6th August 2019

Extension of existing conservatory. Replacement of dormer windows and damaged guttering. Removal of defective render exposing the original brickwork. Reinstating the interior manner sympathetic to its status as a Grade II Listed dwelling. Reinstatement of infilled window, replacement windows, installation of sun tunnels, replacement flat roof, internal/external refurbishment and alterations to entrance gate/steps.

Avola House 16 Tarrant Street Arundel

Thank you for your internet representation made on 5th August 2019 which has been recorded as **'no objection'** with the comments as follows:

PROPOSED EXTERIOR GATE ELEVATION &
PLAN

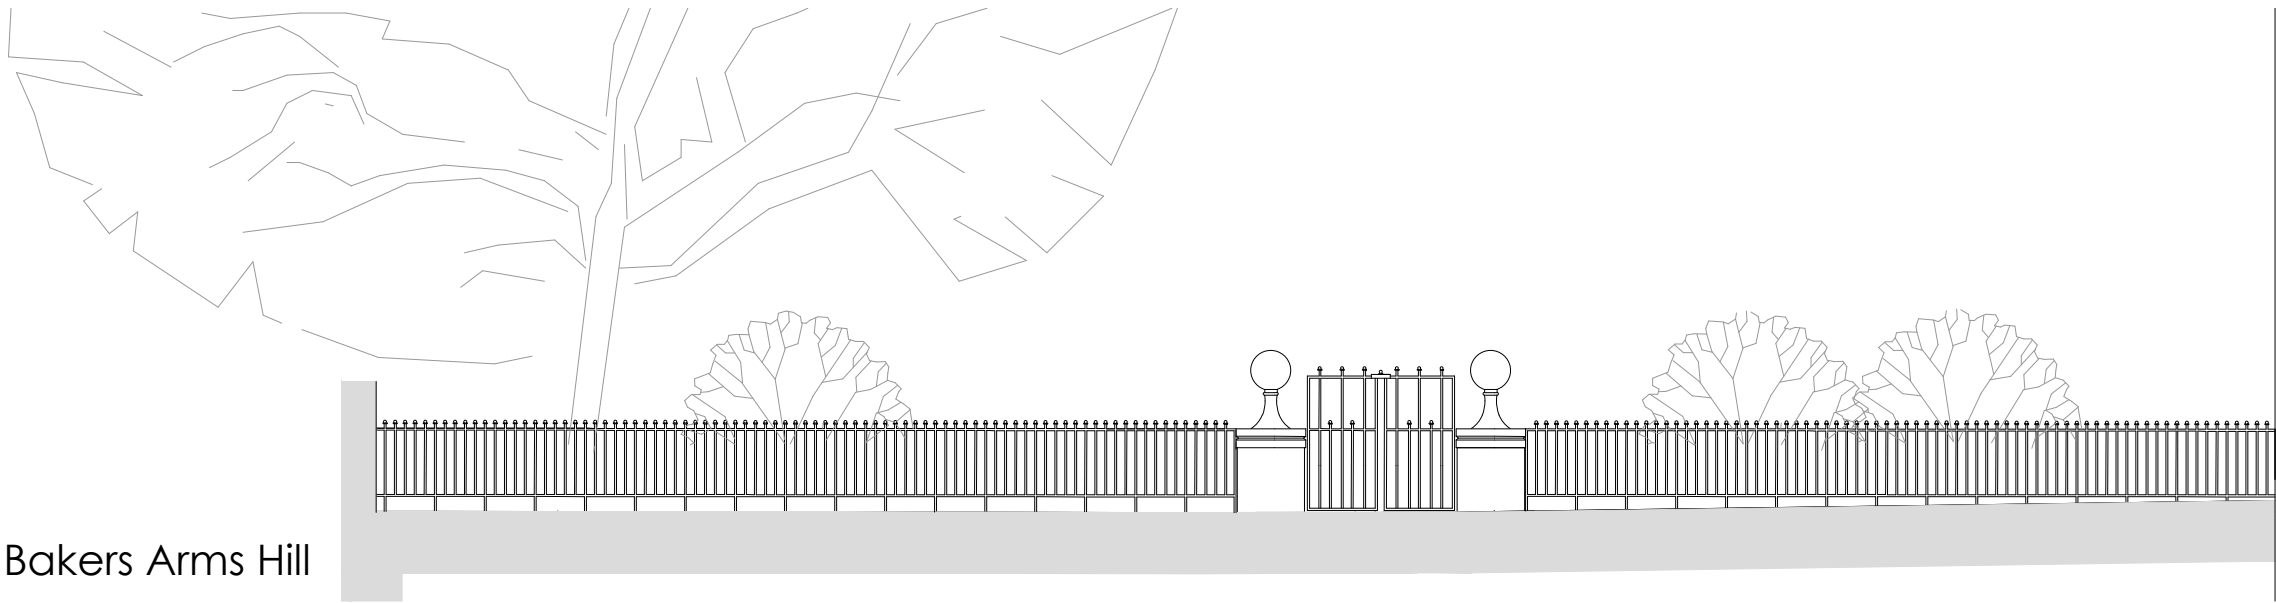
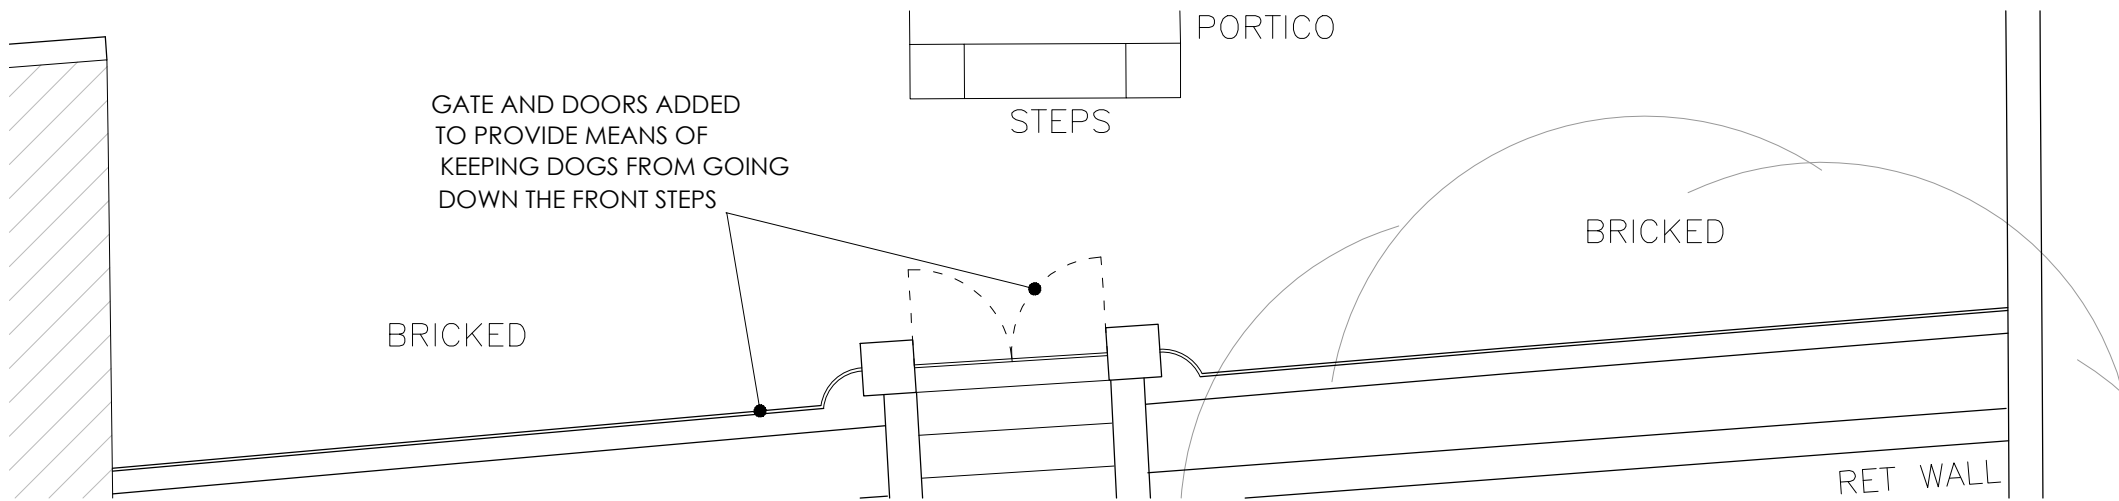
The only matter which perhaps needs further investigation is the heritage significance or otherwise of the blocked windows in the east elevation which are proposed to be opened up. If they were intended from the original construction of the building to be 'blind' windows, then they have considerable heritage significance; if infilled at a much later period, then there is likely to be little significance and their reopening presents no problem. If the Council is minded to grant planning permission/LBC then it is suggested that conditions be attached requiring the submission of precise details of all new joinery and a sample of the brick to be used in repair works. Perhaps larger scale drawings of the new iron balustrading and gates should also be required.
